Ribble Valley Borough Council

App no: 25.0489

**Address: BAE Systems Samlesbury Aerodrome Myerscough Smithy Road
Balderstone BB2 7LF**

**Proposal: Proposed extension to manufacturing facility with associated HV
Substation, external plant compound and new/displaced car park.**

Project:	7295								
Title:	Proposed Car park Site Plan (Planning) - Reduced								
Project no:	7295	Scale:	As indicated	Drawn by:	JL	Checked by:	KC	Date:	24/09/2025
Drawing no:	OSE-WMA-XX-DR-A-00-020	Status:	D2	Rev:	P02

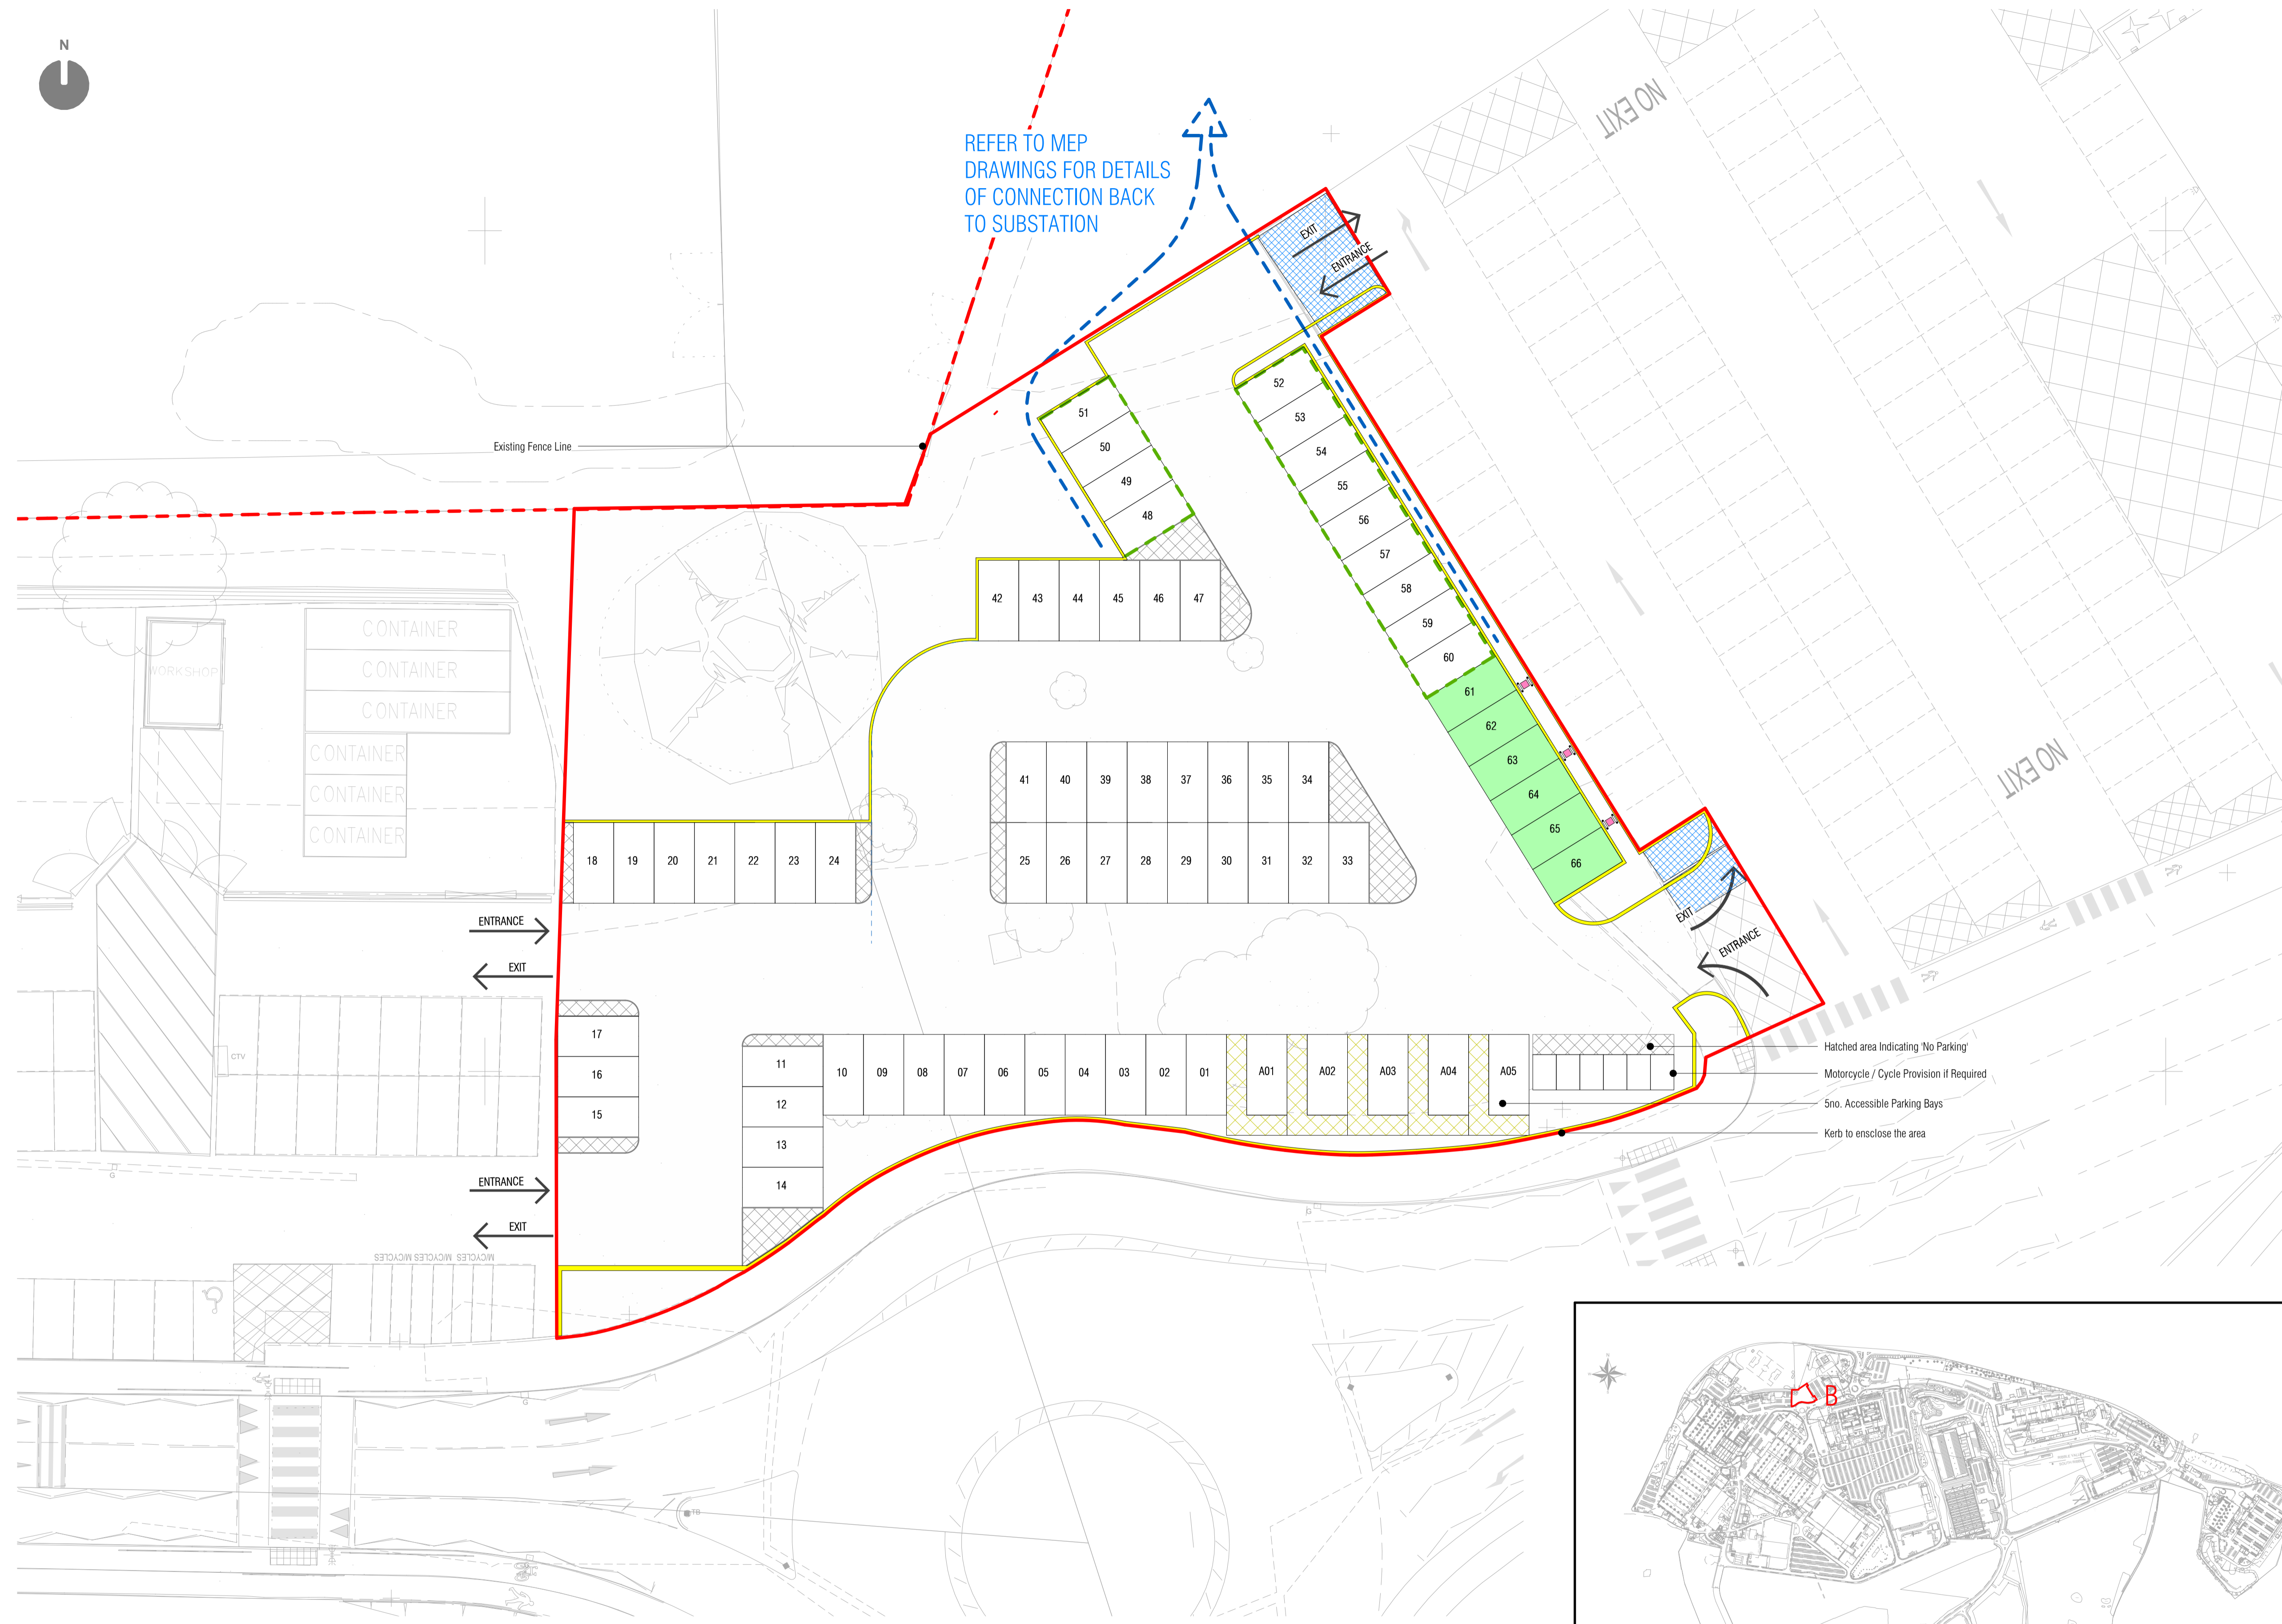
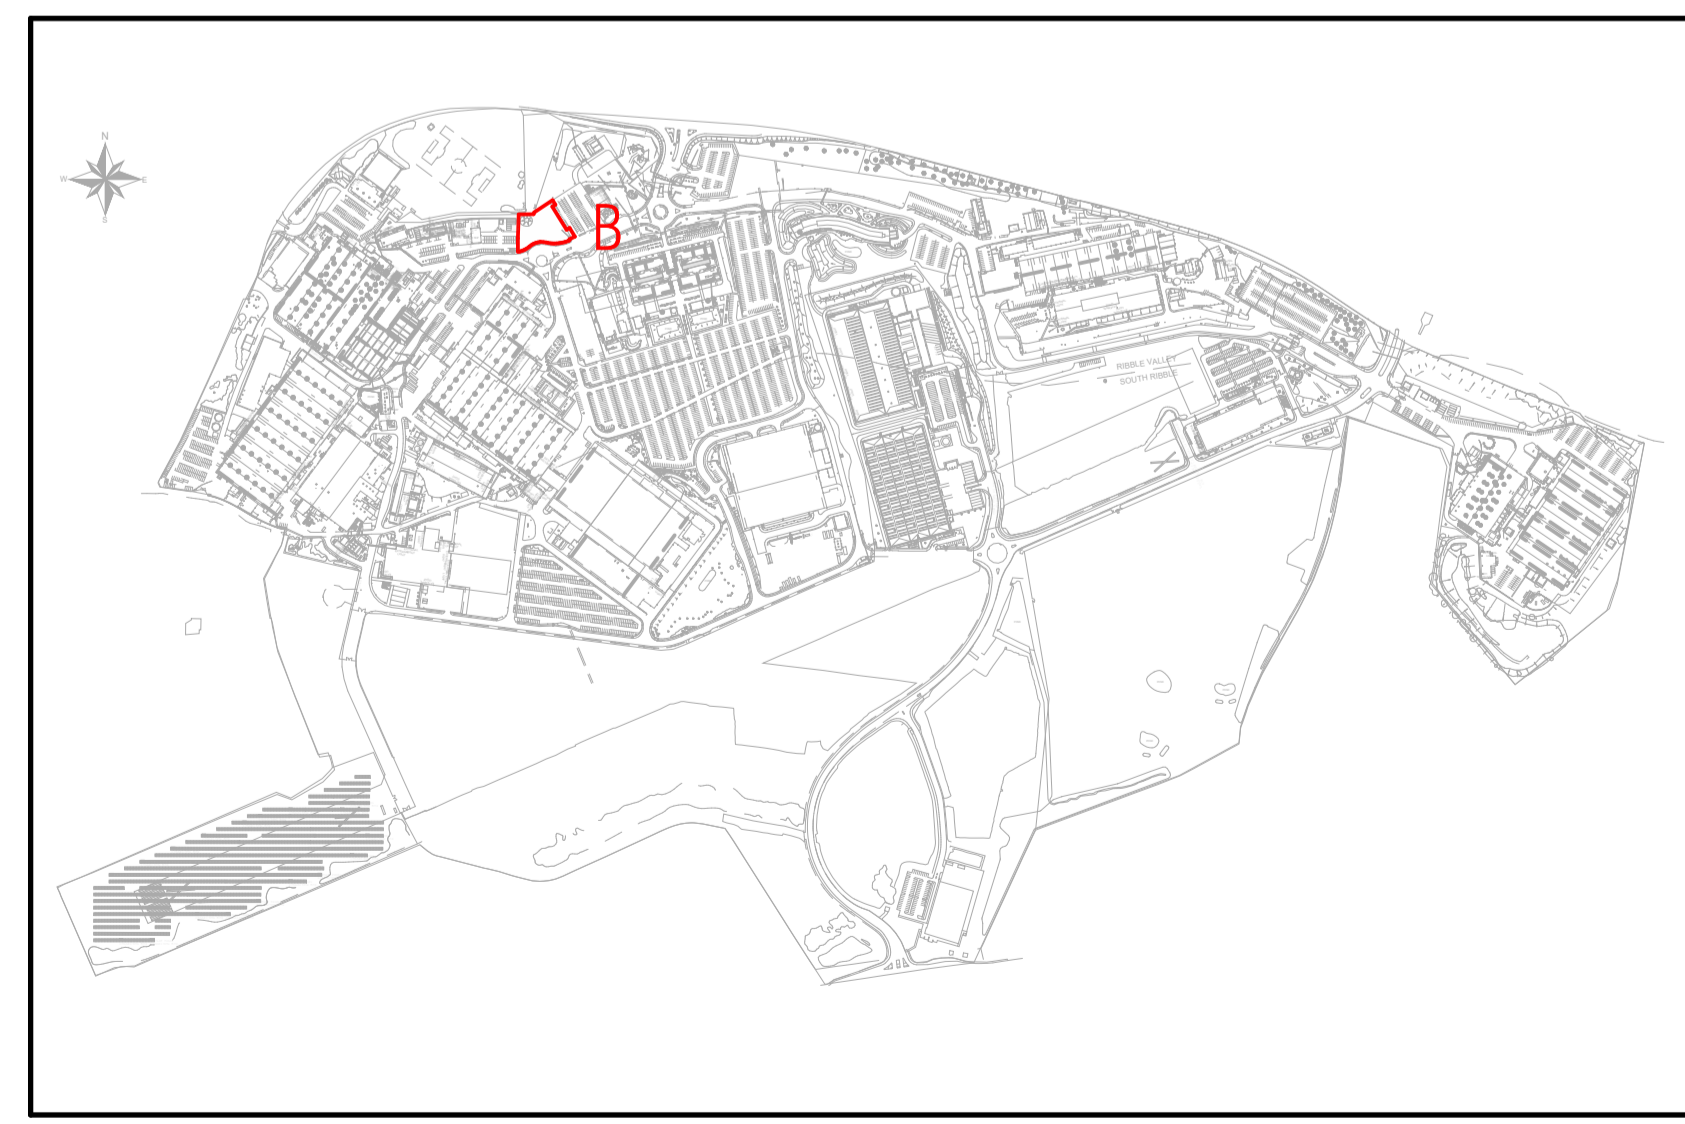
Further to the original comments dated 10th September 2025, the amended car parking plan submitted has been reviewed and the following comments are made.

A new car park scheme has been reduced from 90 to 71 spaces, including 5 accessible spaces and 6 EV charging. There are 6 motorcycle spaces proposed.

The extension results in the loss of 55 car parking spaces, including 2 accessible spaces, the sub-station site results in the loss of 10 car parking spaces and the new car park results in a loss of 5 spaces, totalling 70.

Overall, there is a net increase of 1 space at the site.

Based upon a B2 facility of 1800sqm we would expect to see a parking provision of 40 spaces, reduced to 26 if considered to be a highly accessible site with on-site facilities. This is a shortfall however there are no additional employees proposed as a result of the proposal therefore demand is not anticipated to increase.

It is noted that there is no active car park management of where staff park in the various car parks across the site. The Highway Authority has no reports of overspill car parking from the site onto the surrounding highway network.

We would consider the car parking provision to be acceptable.

We would request that secure and covered cycle parking is provided to support staff to travel sustainably to site, if not already provided at the site.

1. Prior to first use of the development hereby permitted the replacement car parking shall be provided in accordance with the approved plan. Reason: To provide adequate car parking on site.
2. Prior to first use of the development hereby permitted a secure and covered cycle store for 9 bicycles shall be provided and maintained thereafter. Reason: To support sustainable travel.
